From: James Hughes (The Victorian Society) <james@victoriansociety.org.uk>
Sent: 30 November 2016 12:04
To: DCAdmin; Louise Bearcroft
Cc: Elisabeth.Lewis@HistoricEngland.org.uk; Lucie Carayon (lucie.carayon@ancientmonumentsociety.org.uk); Nigel Hunston
Subject: 2016/92030 and 2016/92029: 20-24 Cross Church Street, Huddersfield
Attachments: Huddersfield, 20-26 Cross Church Street 2016-01-017 (2).pdf

RE: 20-24 Cross Church Street, Huddersfield (Grade II, C19); application for the extension of the Kingsgate Shopping Centre and the partial demolition of listed buildings

Our ref: 2015/01/017

Content **ART LOCATION PLAN**
 Client **WD KINGSGATE LTD**
 Project **KINGSGATE LEISURE**

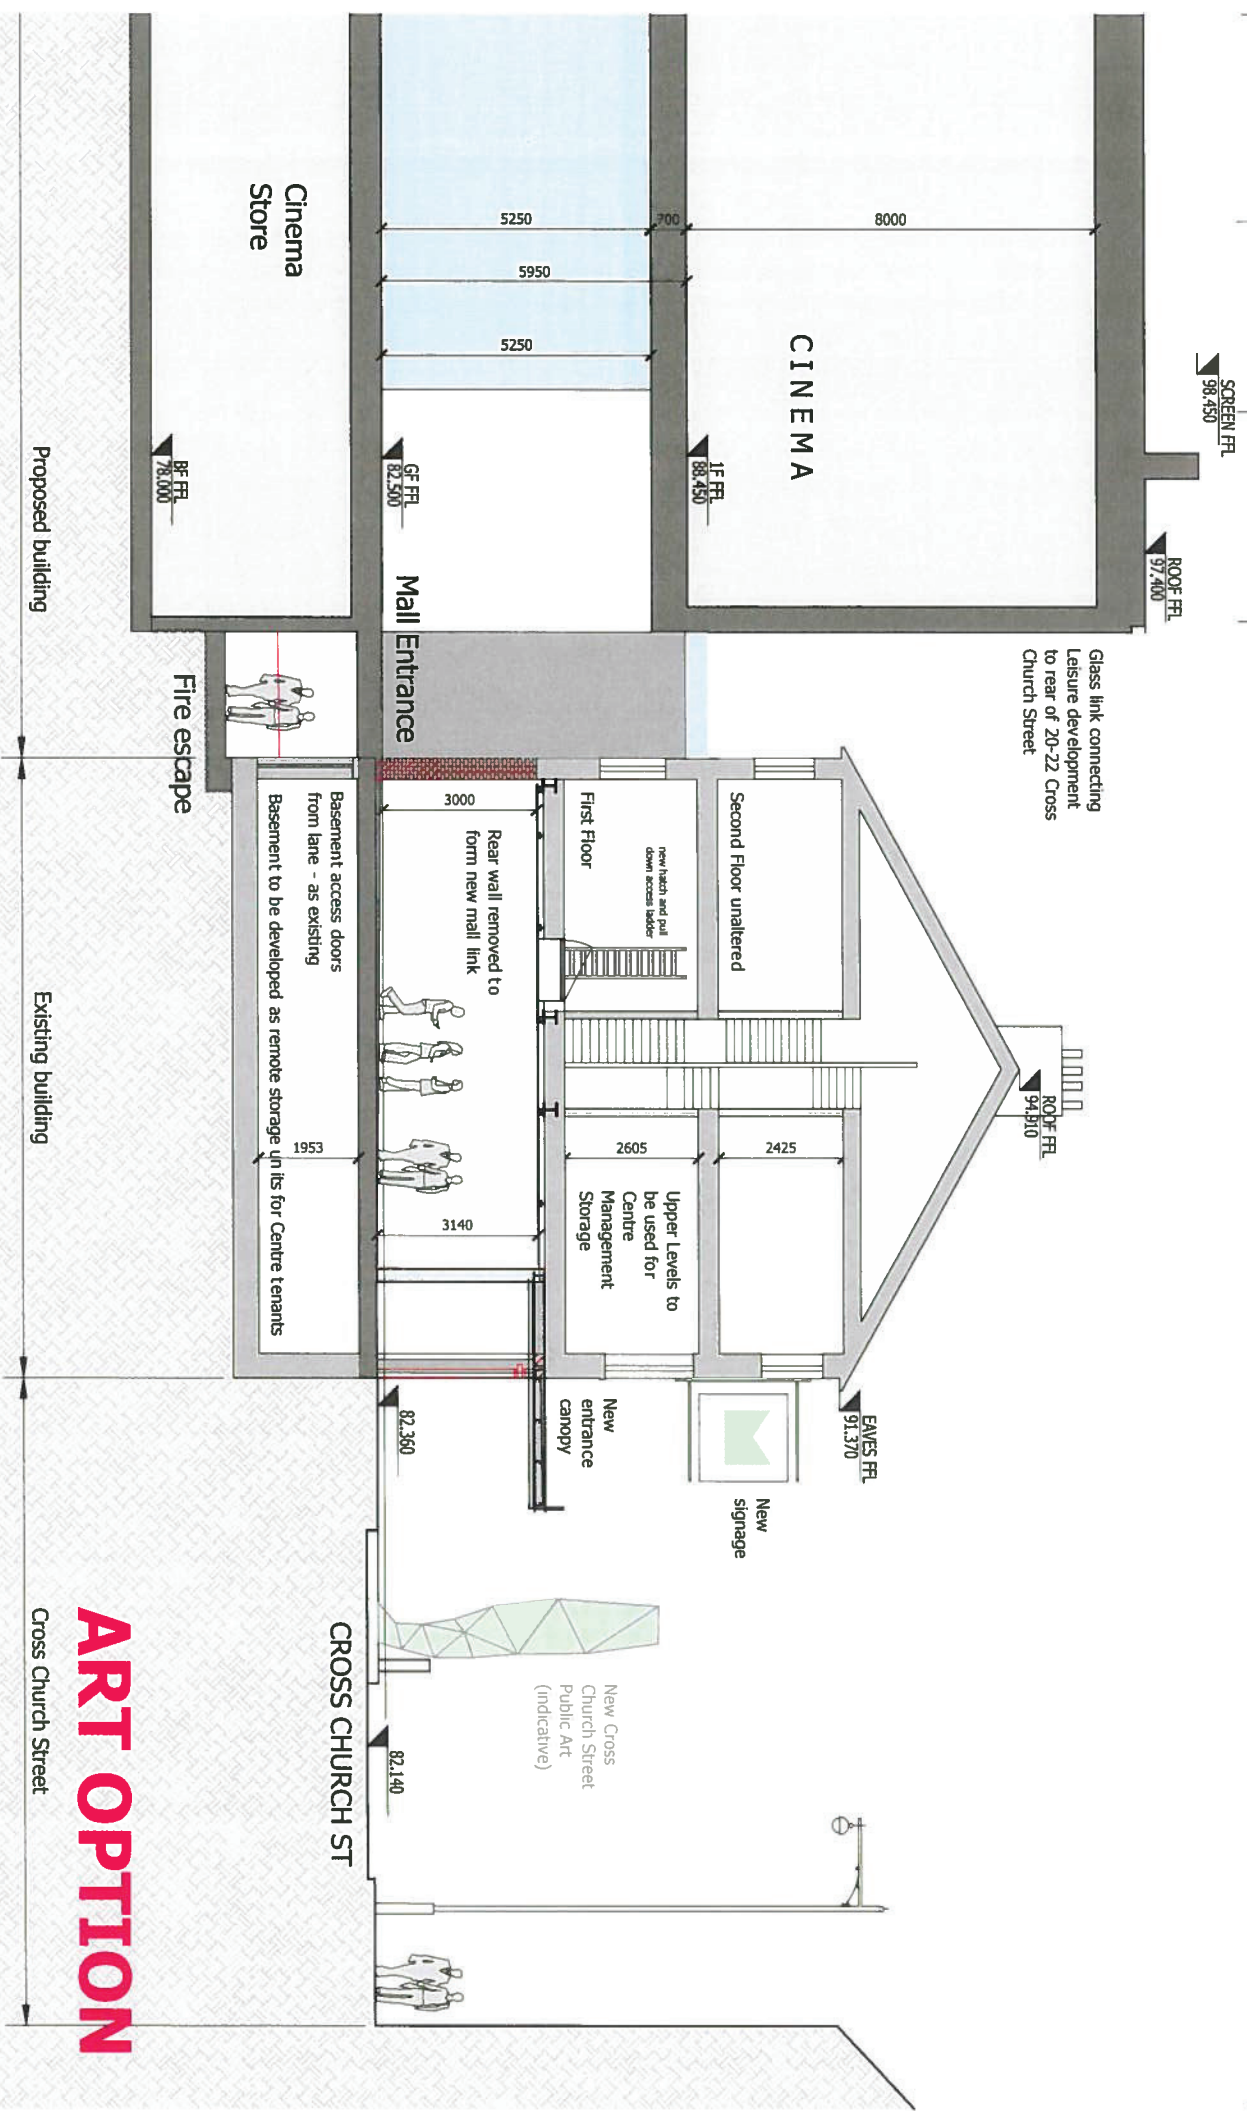
Despite the evident improvements, however, we maintain our objection to the application on two principal grounds: firstly, the proposed canopy and totem waymarkers, which we have consistently recommended are omitted from the scheme, remain a part of the proposals. For the reasons outlined in my previous letter (a copy of which is attached) we object to this damaging aspect of the proposals.
